COLORADO GEOLOGICAL SURVEY

June 12, 2017

Subject: The Retreat @ TimberRidge PUD
File Number PUD173; El Paso County, CO; CGS Unique No. EP-17-0048

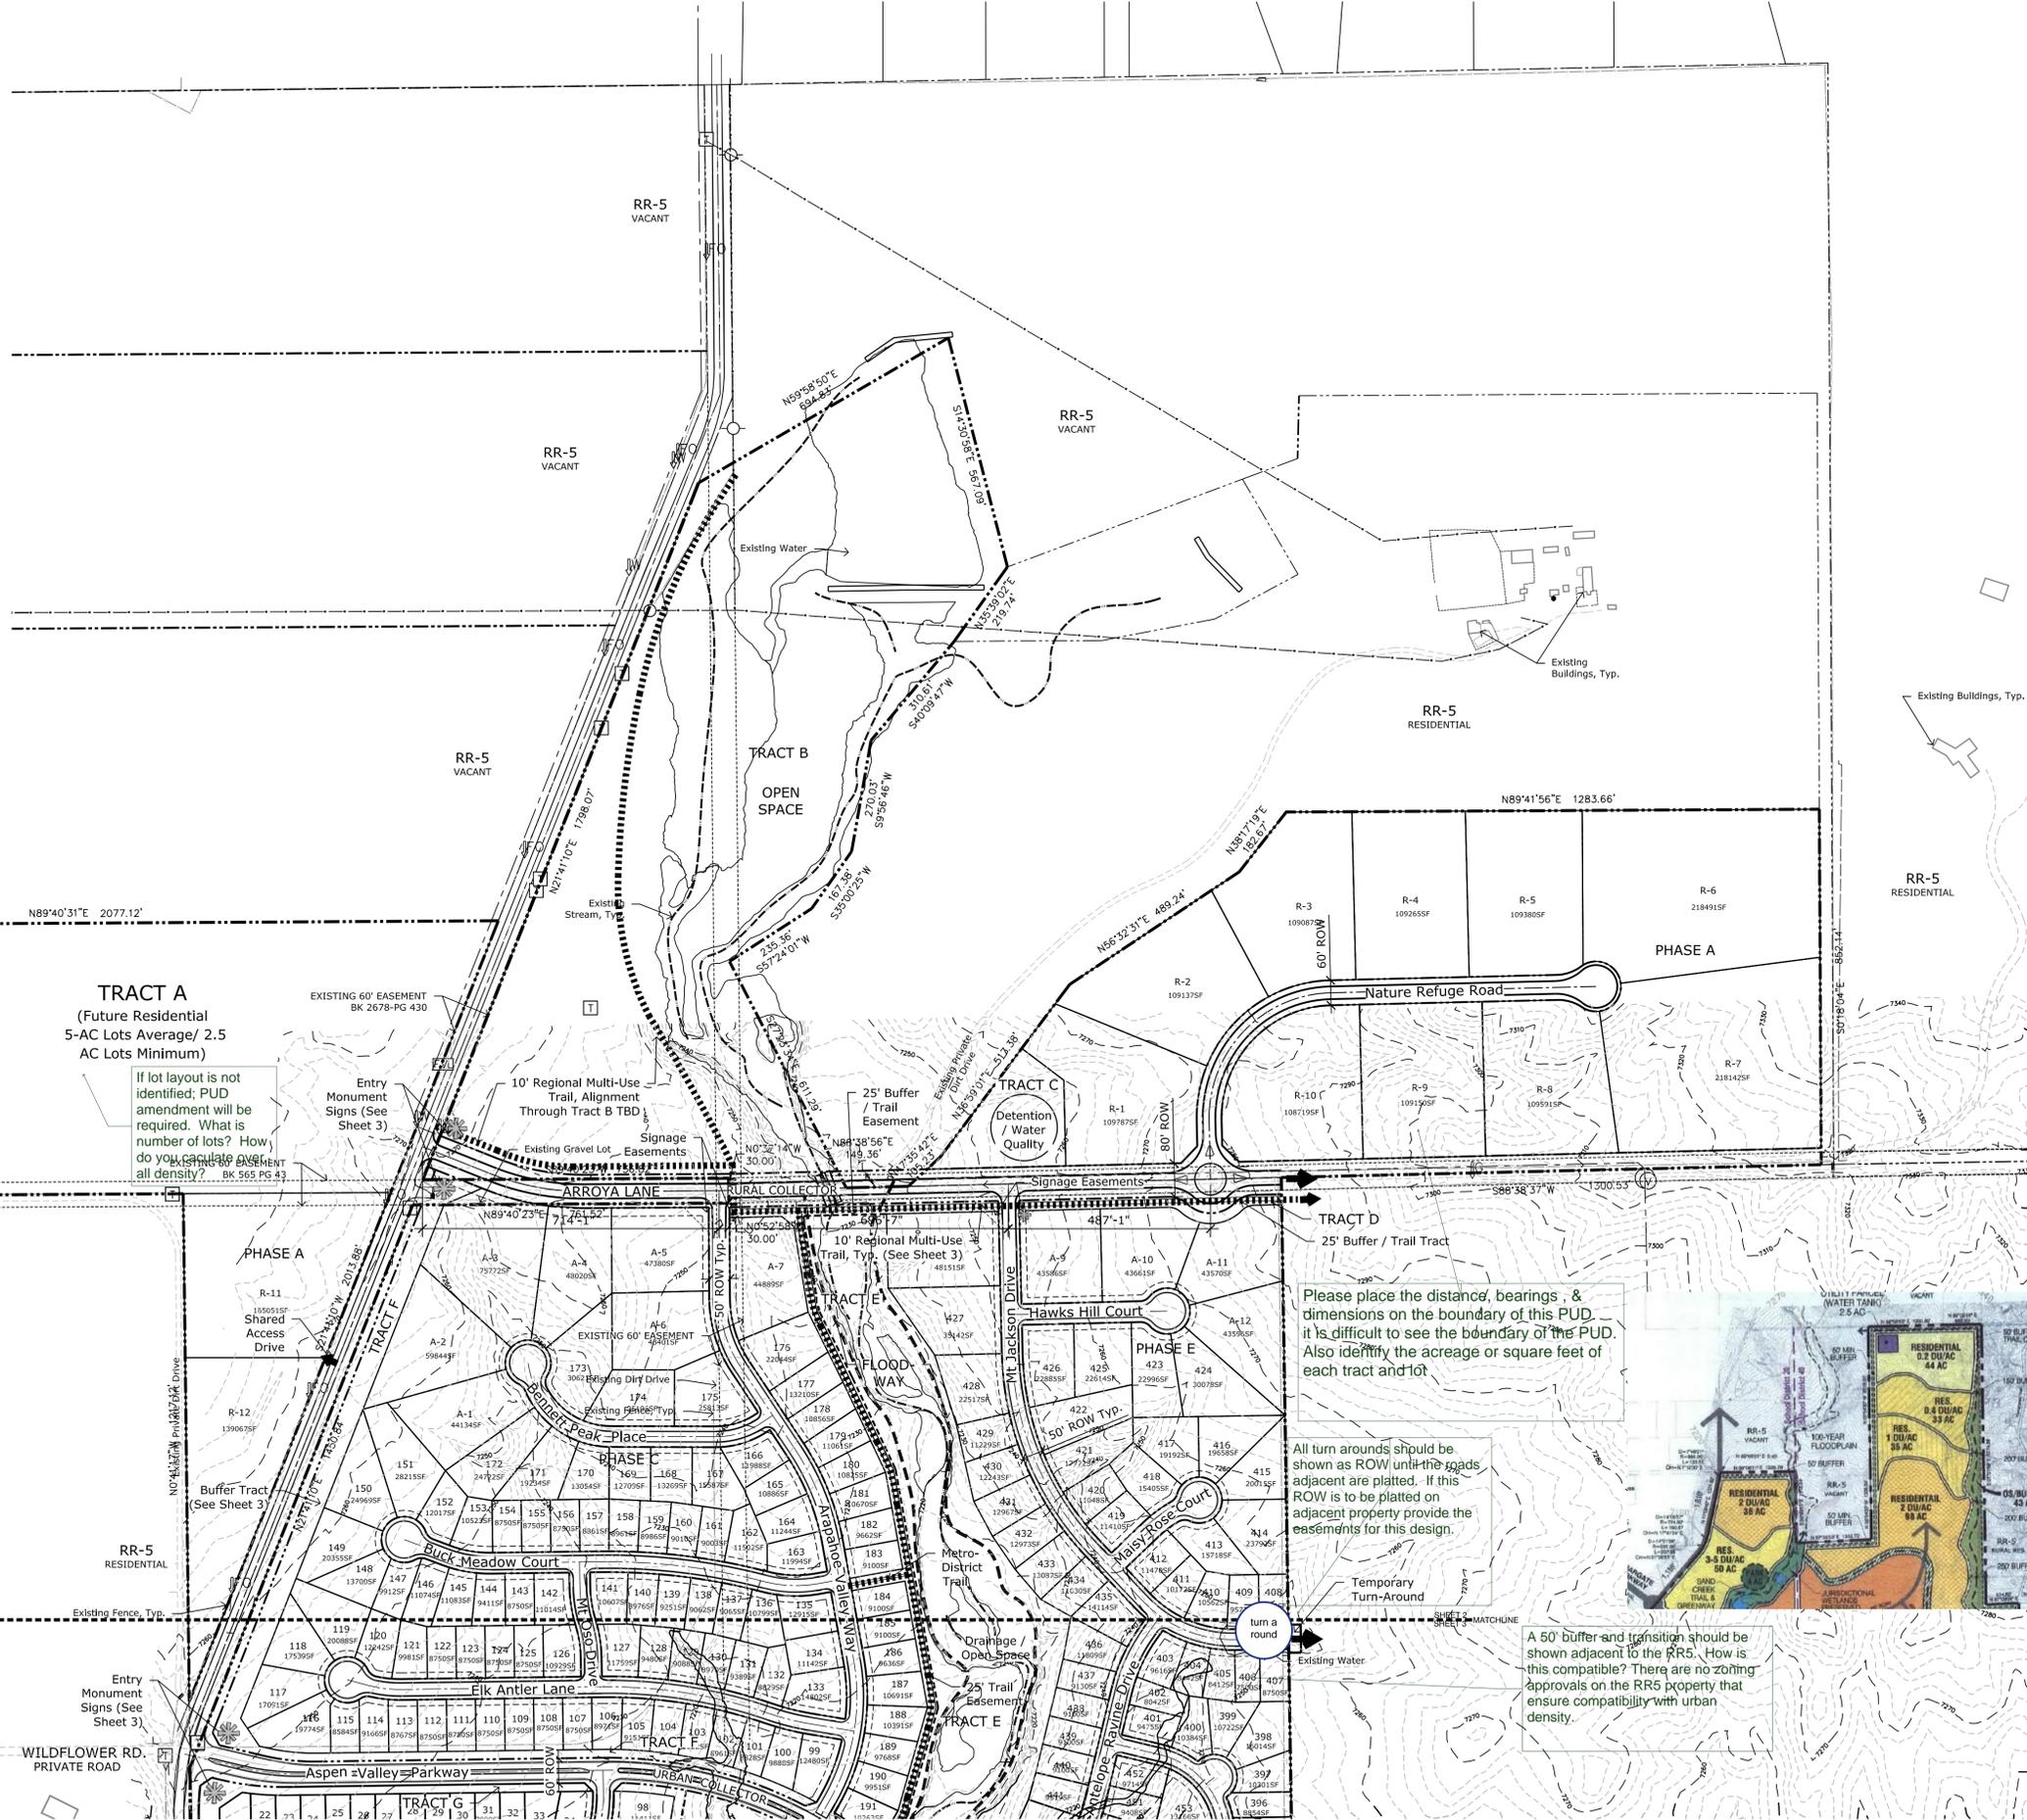
Shallow groundwater and basement feasibility. Entech notes evidence of seasonally shallow groundwater at depths of 5 to 6 feet in test pits 2 and 3, corresponding to proposed lots R-10 and R-11, and water was observed at 5 feet in test boring 2, located close to Sand Creek approximately behind proposed lots 213-215. Entech maps areas of seasonal shallow water (sw) and potential seasonal shallow water (psw) in many areas of the site, generally corresponding to Sand Creek and smaller drainages. It does not appear that there is a widespread shallow groundwater condition that would preclude full-depth basement construction on most or all proposed lots. Entech states (page 7), "Builders and planners should be

cognizant of the potential for the occurrence of such subsurface water features during construction on-site and deal with each individual problem as necessary at the time of construction.” This *may* be a valid strategy for mitigating instances of thin, discontinuous water-bearing sand and gravel lenses and intermittent perched water conditions, but additional investigation and analysis are recommended to confirm the feasibility of below-grade construction on lots where basements are proposed adjacent to Sand Creek and in Entech’s observed shallow groundwater areas.

Lowermost floor levels *must* be located at least three feet above maximum anticipated groundwater levels, to reduce the risk of water infiltration into below-grade spaces, and damp, mold-conducive conditions. Full-depth basement construction should therefore not be allowed where shallowest seasonal water levels are less than about 11 feet below the ground surface (more if basement heights greater than 8 ft. are planned). Individual foundation perimeter drains are intended to handle small amounts of intermittent, perched water, and are *not* to be used to mitigate a persistent shallow groundwater condition.

Erosion setback. No lots appear to encroach on the mapped Sand Creek flood hazard zone. However, CGS recommends a conservative setback from flood zone boundaries and Entech’s mapped potentially unstable slopes (Entech’s Figure 7 in both reports) to reduce hazards associated not just with rising floodwaters but also erosion, scour, and local slope failures. The setback should be determined based on site-specific analysis of topography and soil erosion properties, and should be specifically identified on the plat as non-buildable. The value of a conservative setback was demonstrated during the flood event of September 2013 in Boulder and Larimer Counties.
